Please find enclosed our letter of objection in respect of Planning Reference CM/23/17/PL for the Erection of 1 Number Dwelling with Detached Garage on Land at the Entrance to Waterford Gardens.

**Erection of 1 Number Dwelling with Detached Garage
Land at The Entrance to Watersford Gardens, Horsemere Green Lane
Planning Reference CM/23/17/PL. Case Officer Mrs A Gardner**

Site Plan

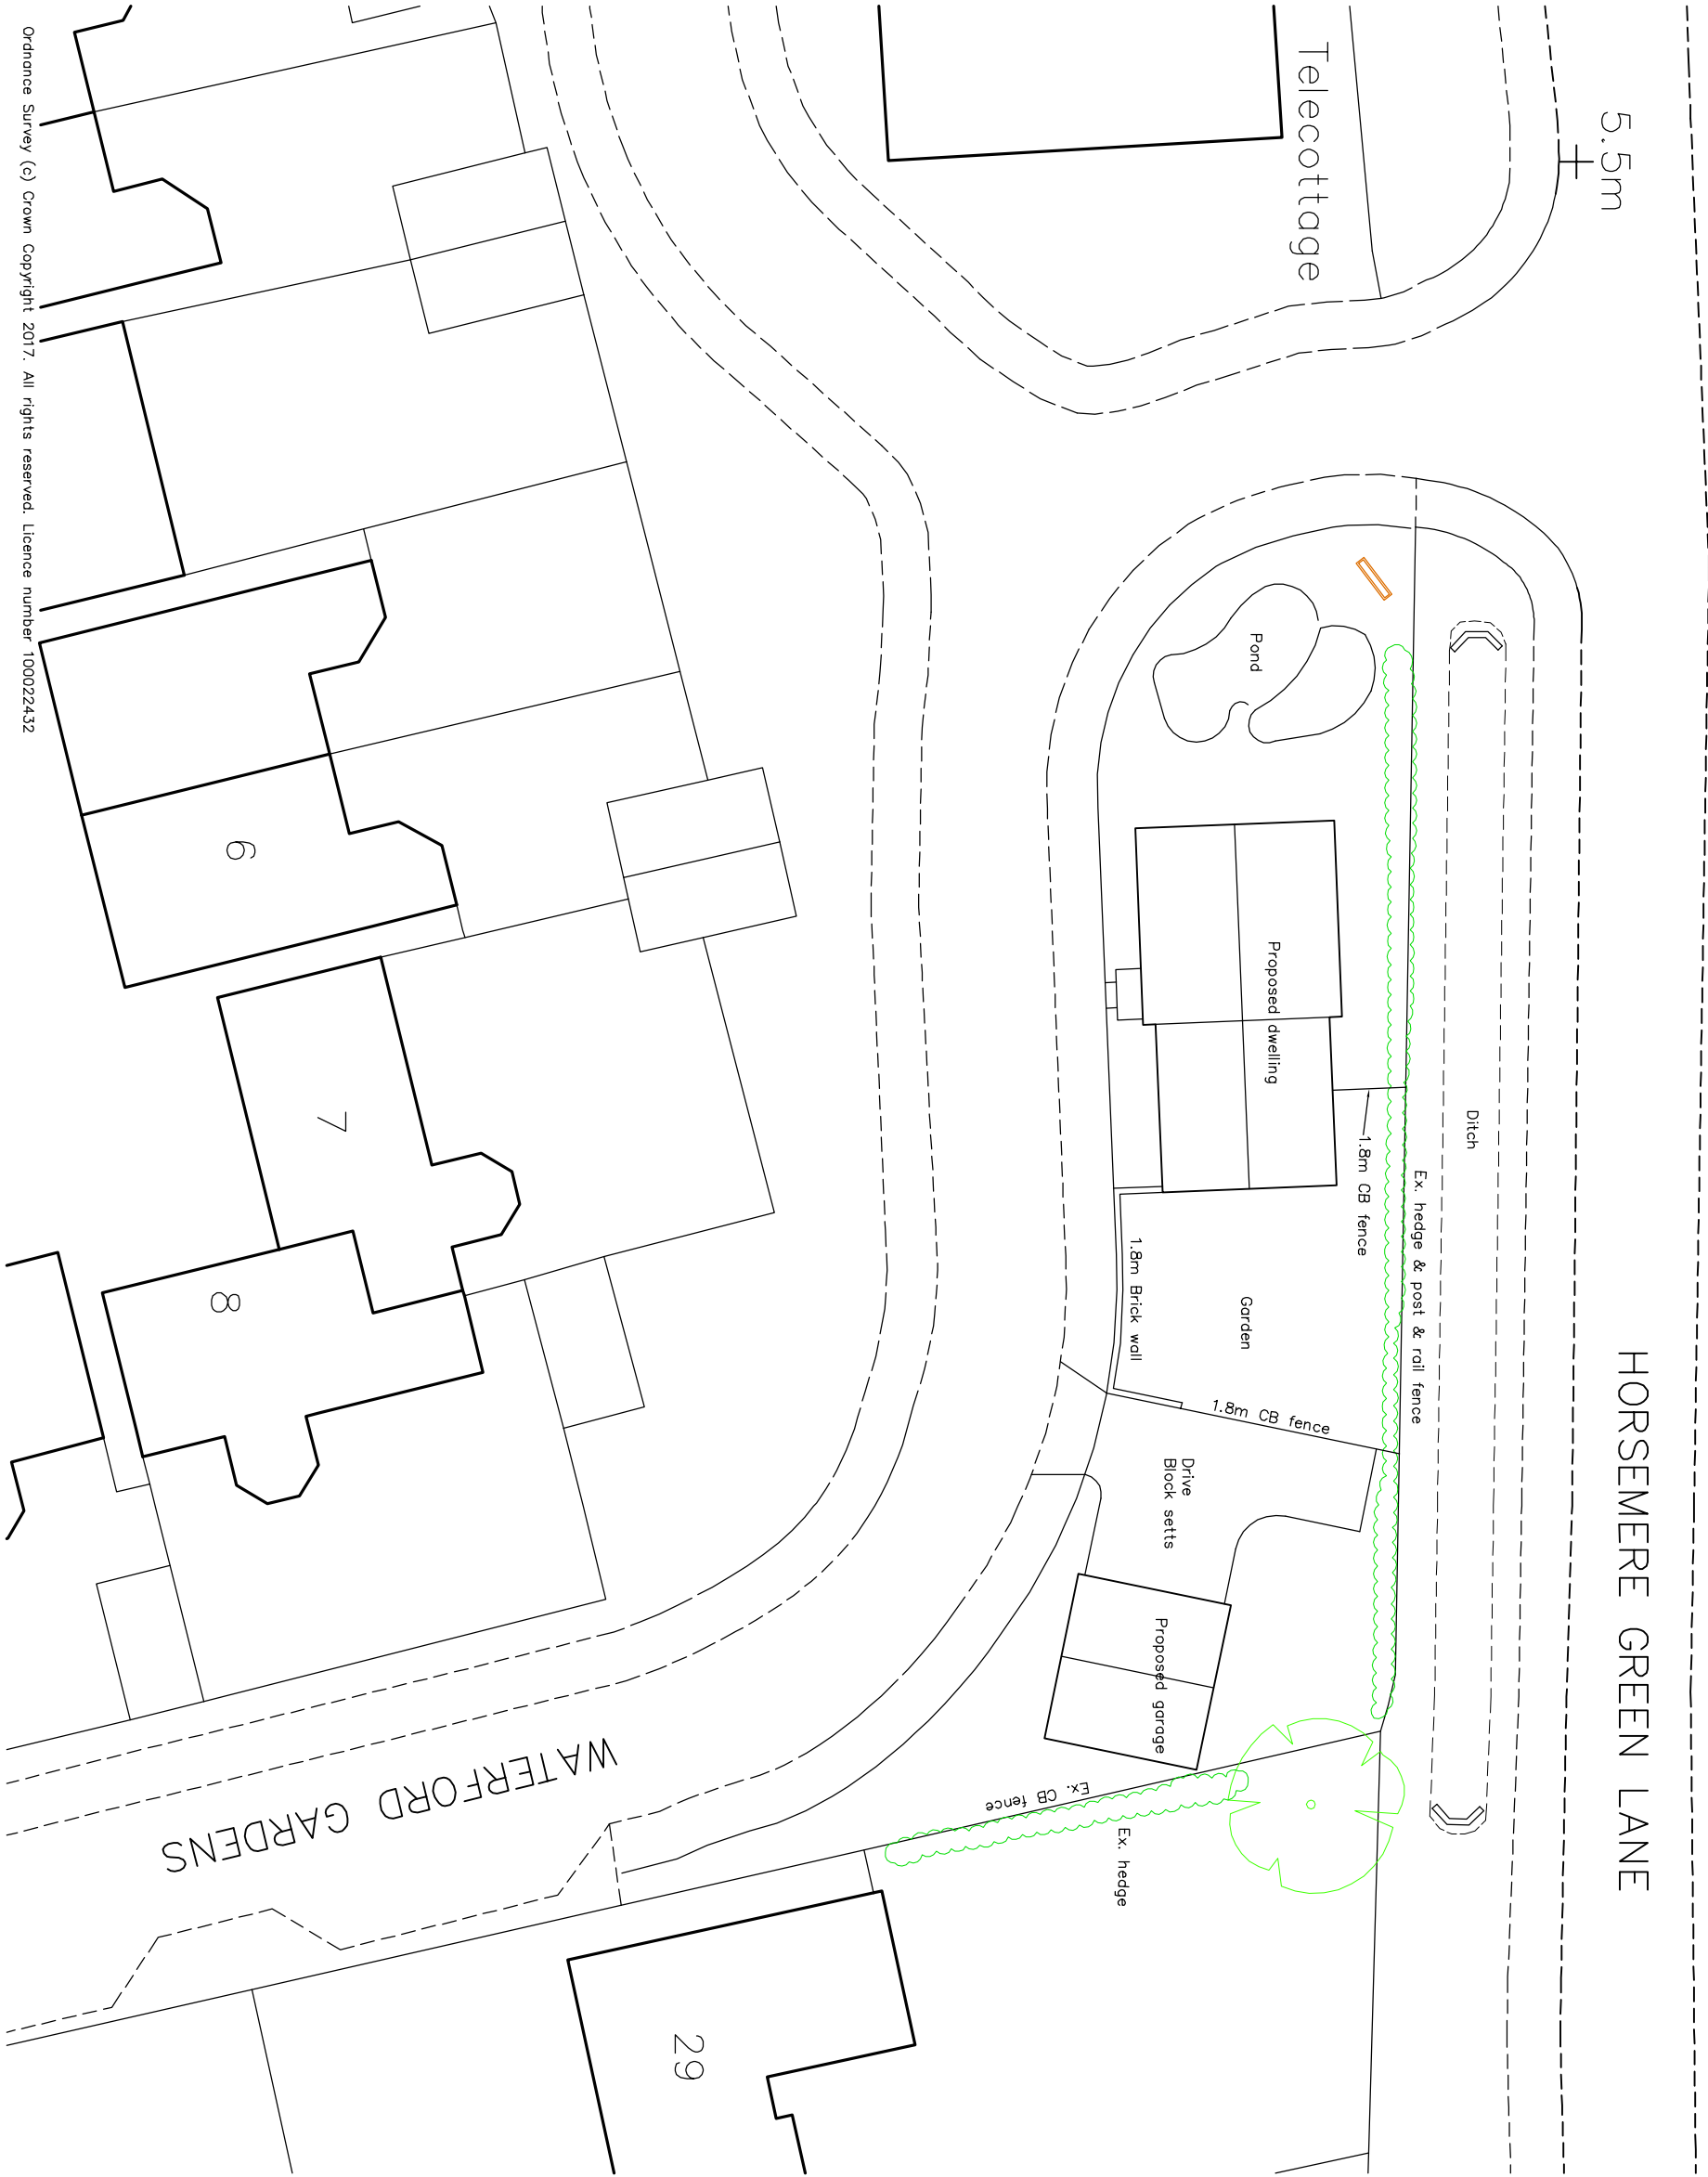
- 5) ADP Architects Drawing 1408 02 dated February 2008 and Drawing 1408 100 dated February 2017 do not match and are not consistent.
- 6) There is no Planning, Design, Access Statement and No Lighting Assessment has been completed or submitted.

Double Garage

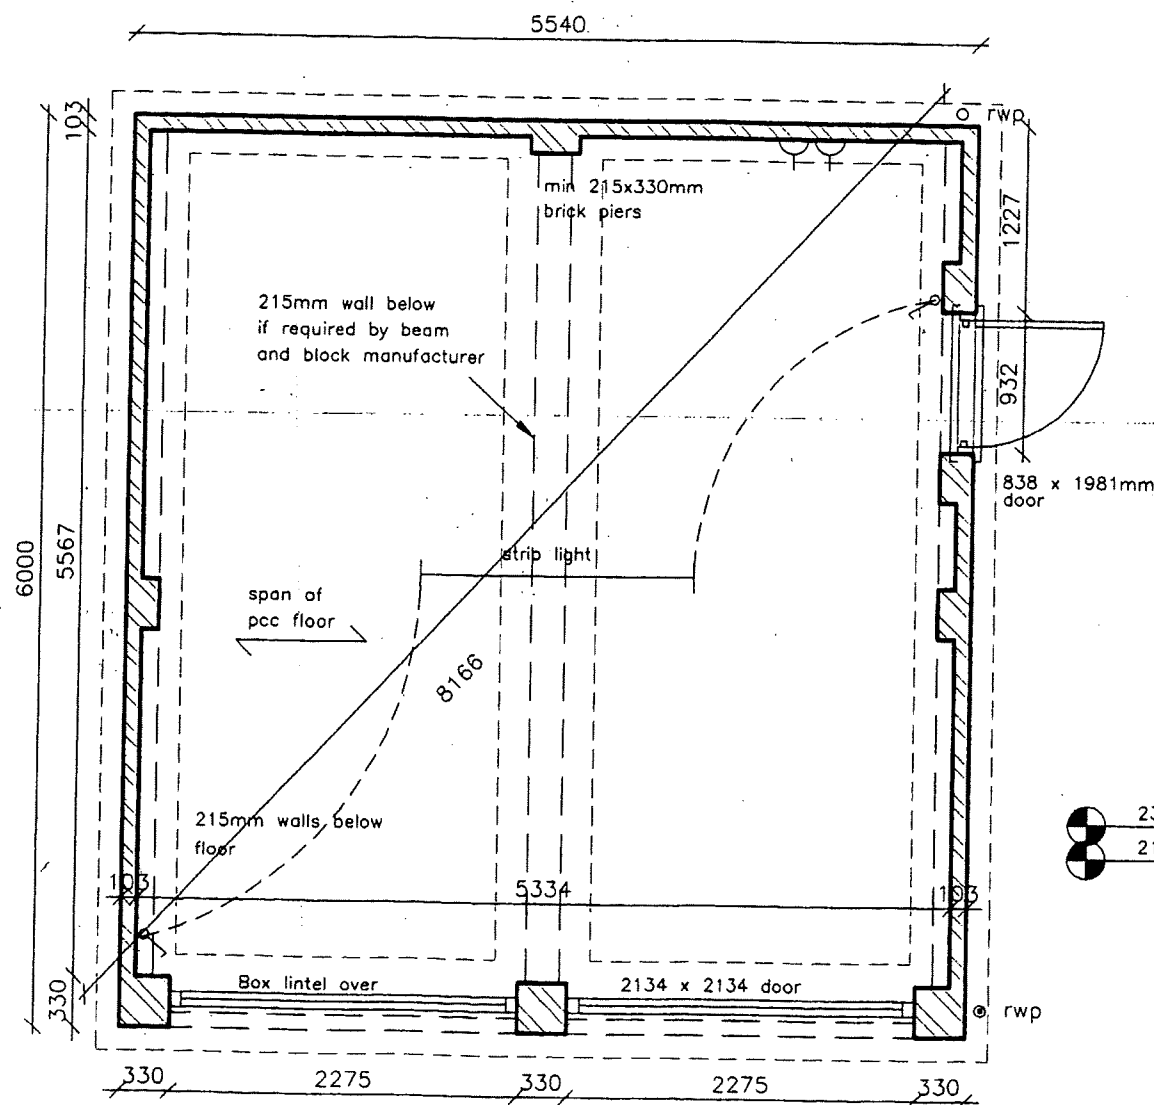
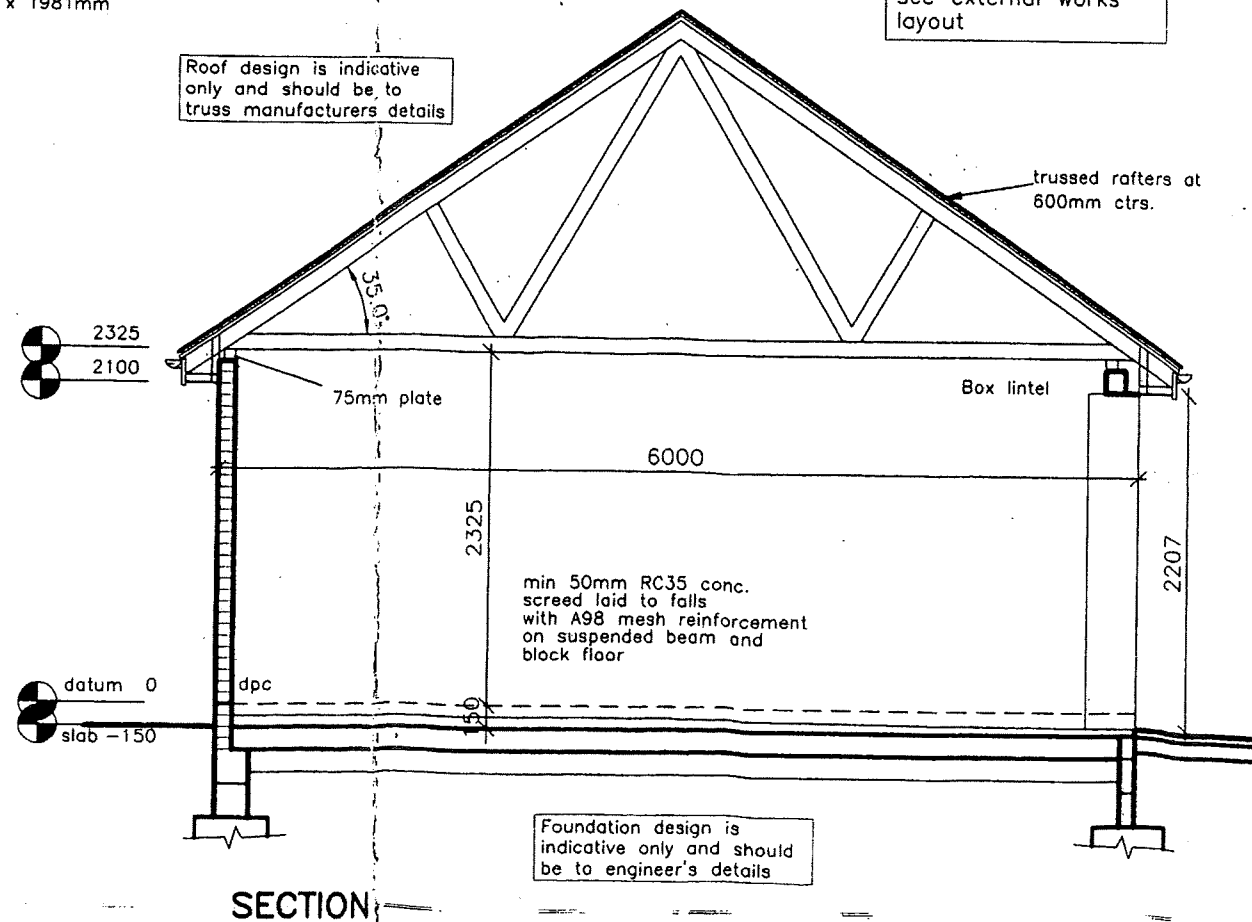
- 12) Domination of adjoining property at 29 Crophorne Drive with the proposed garage height of 4.7m. This will be 2.9m above the height of the boundary fence.

14) Proximity of the proposed double garage to 29 Crophorne Drive.
